# CITY OF ALBUQUERQUE

RE: **ABQ Ride Daytona Transit Facility**  
**Grading and Drainage Plan (Engineer's Stamp Date: 6/14/17)**  
**Coversheet Stamp Date: 6/1/17**  
**Hydrology File: J09D025**

Based on the information provided in your submittal received on 6/23/17, the Grading and Drainage Plan cannot be approved for Building Permit until the following comments are addressed:

Profile Report Engineering Profile - Daytona SD (Ex&PropSD Option1.stsw)

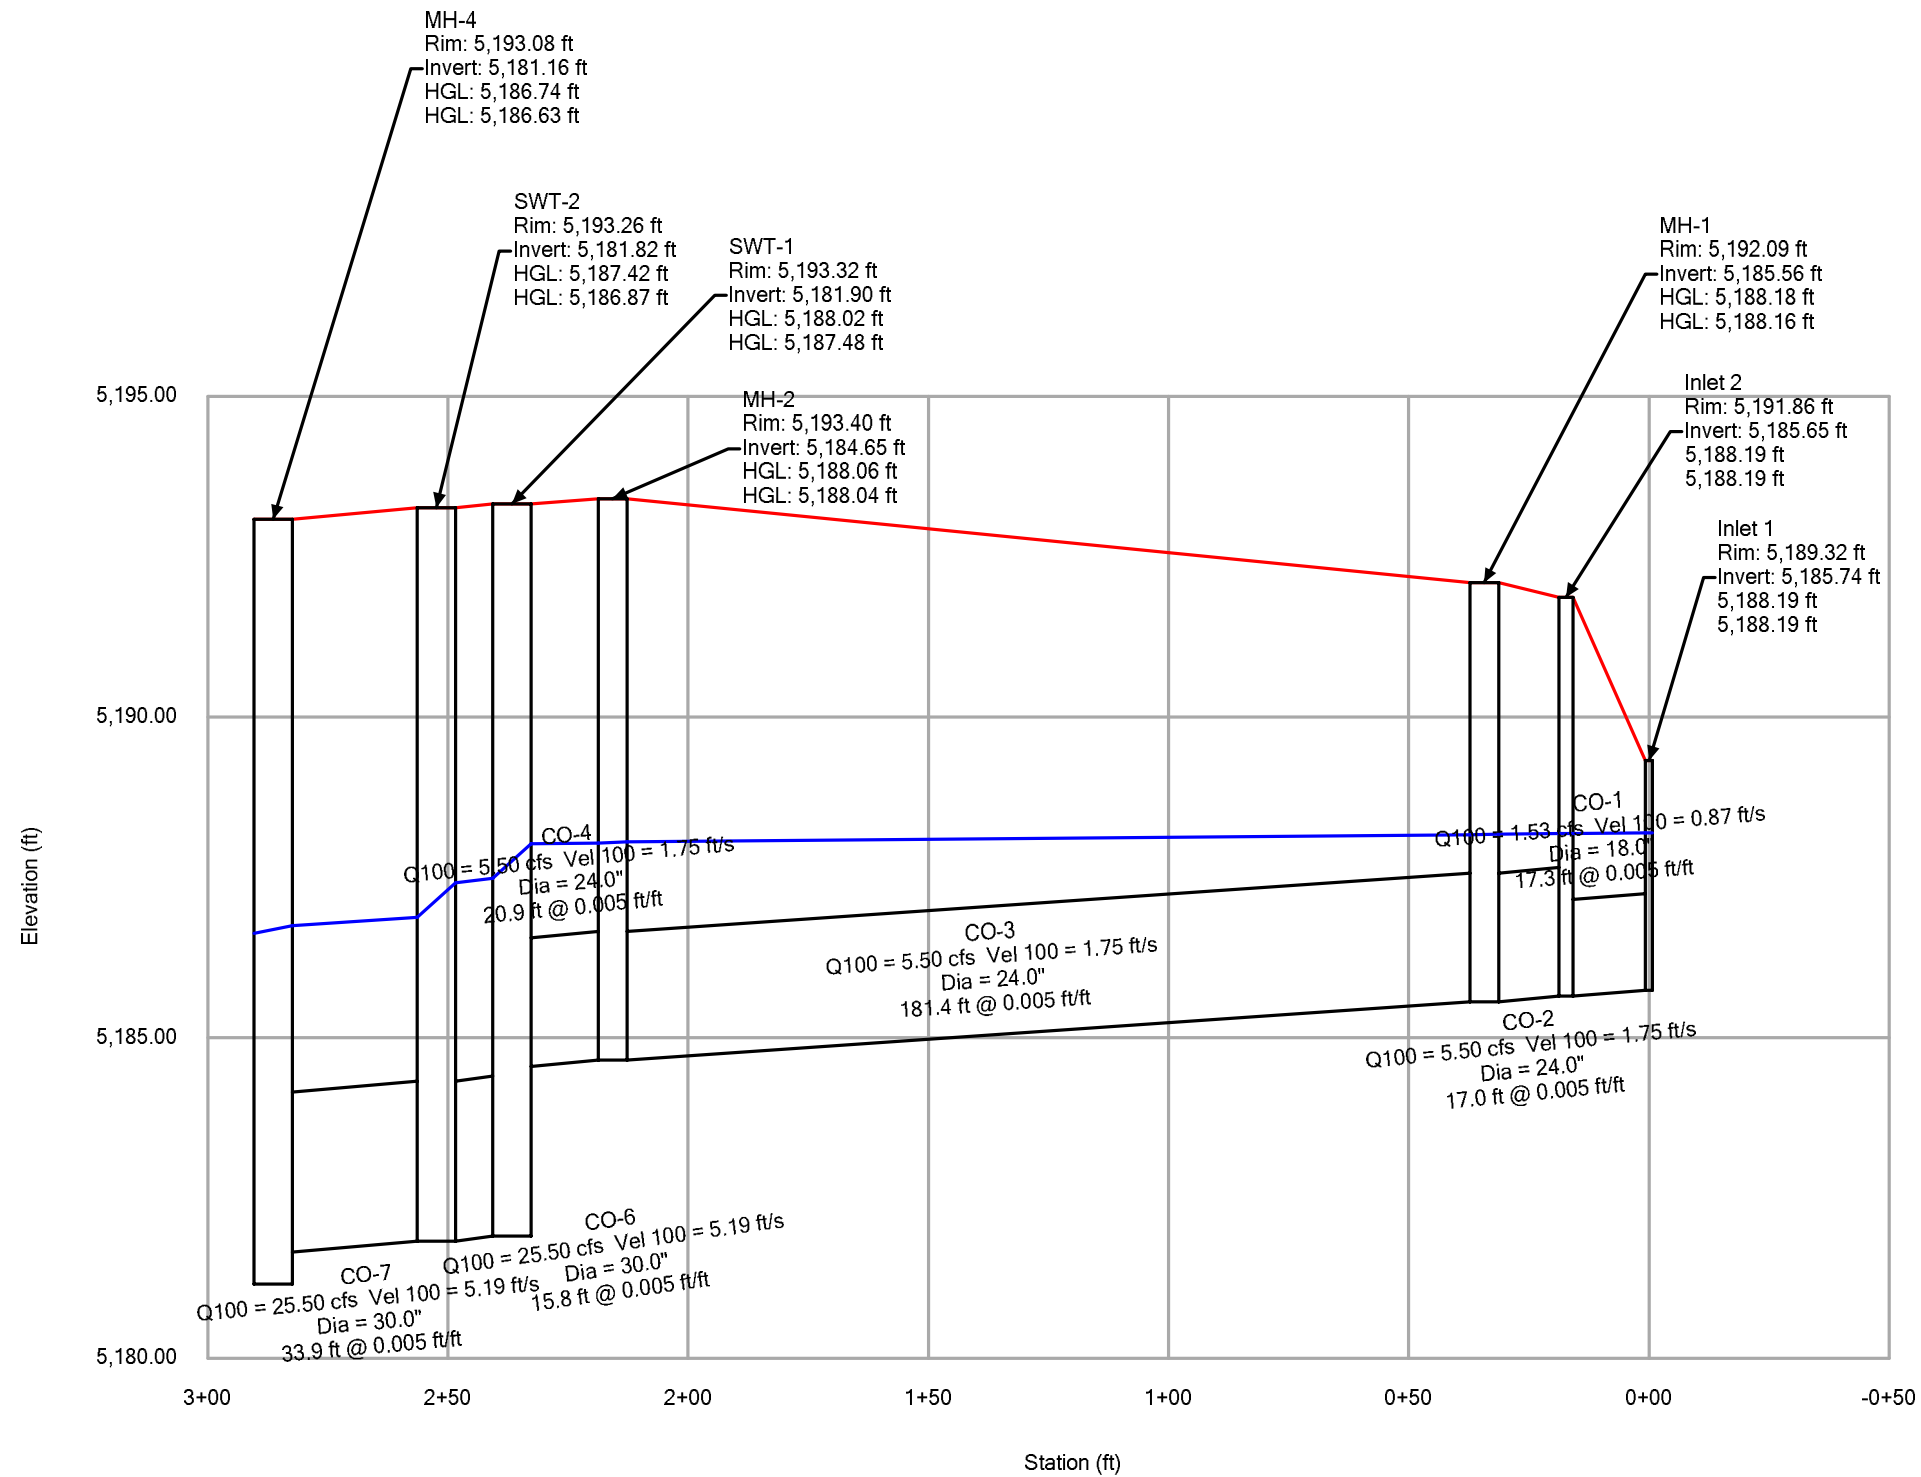
3. Pipe profiles and supporting data need to be included: flow (100yr), velocity, HGL, and junction losses through the various manholes and water quality features.

LANDSCAPE AREA SECTION, TYPICAL
N.T.S.

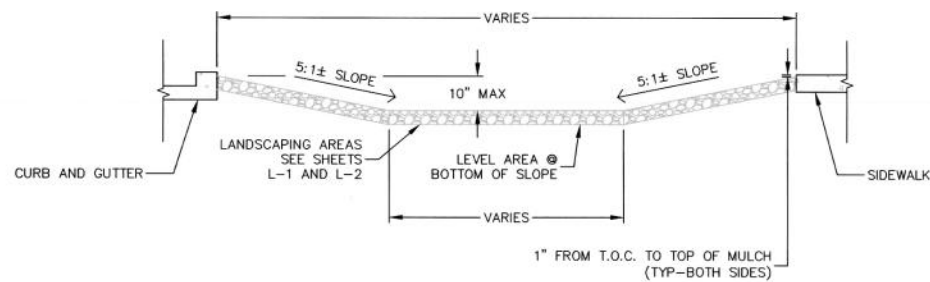
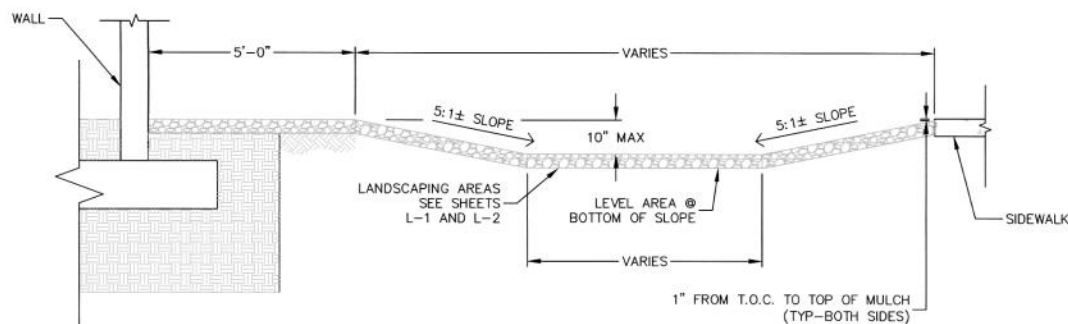
1. How are the depressed ponding areas in the landscape buffers being built? There are details provided, but they are not called-out anywhere. The grading plan does not include grading to create these areas, and the landscaping sheets don't show any depressed areas or call-outs to create them.
